PLANNING AMENDMENT

H05/0116/02/41

ELECTION 2 STOREY SIDE
EXTENSION + DETACHED
DOUBLE GARAGE.

Amendment: Revisions to Roof Trusses

Amended Drawing showing
changes to roof trusses

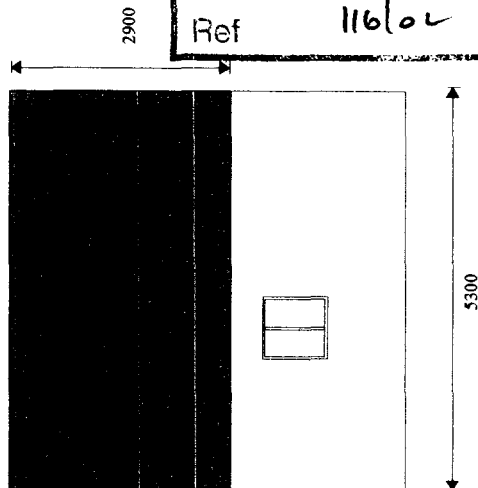
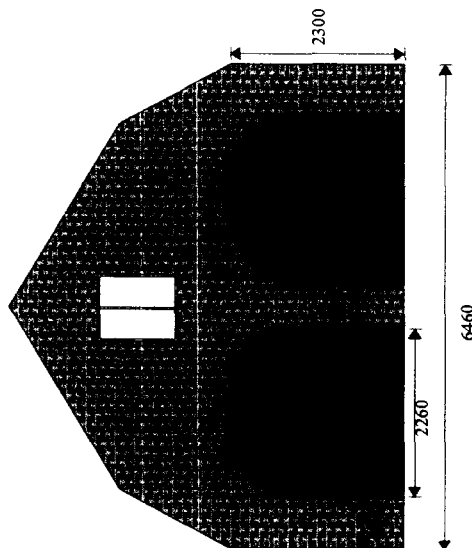
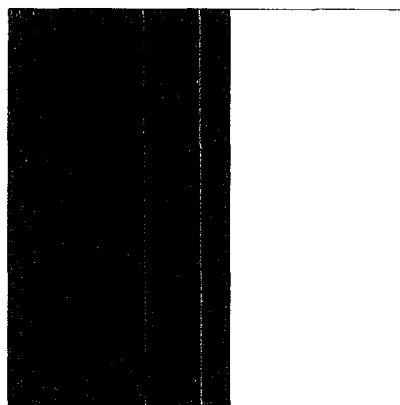
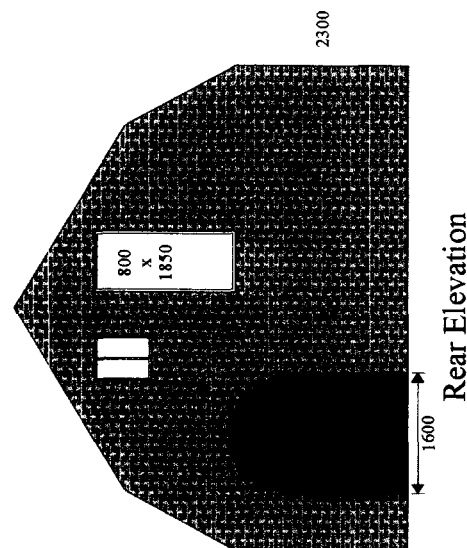
AMENDED ROOF
TRUSSES - SEE PLAN.
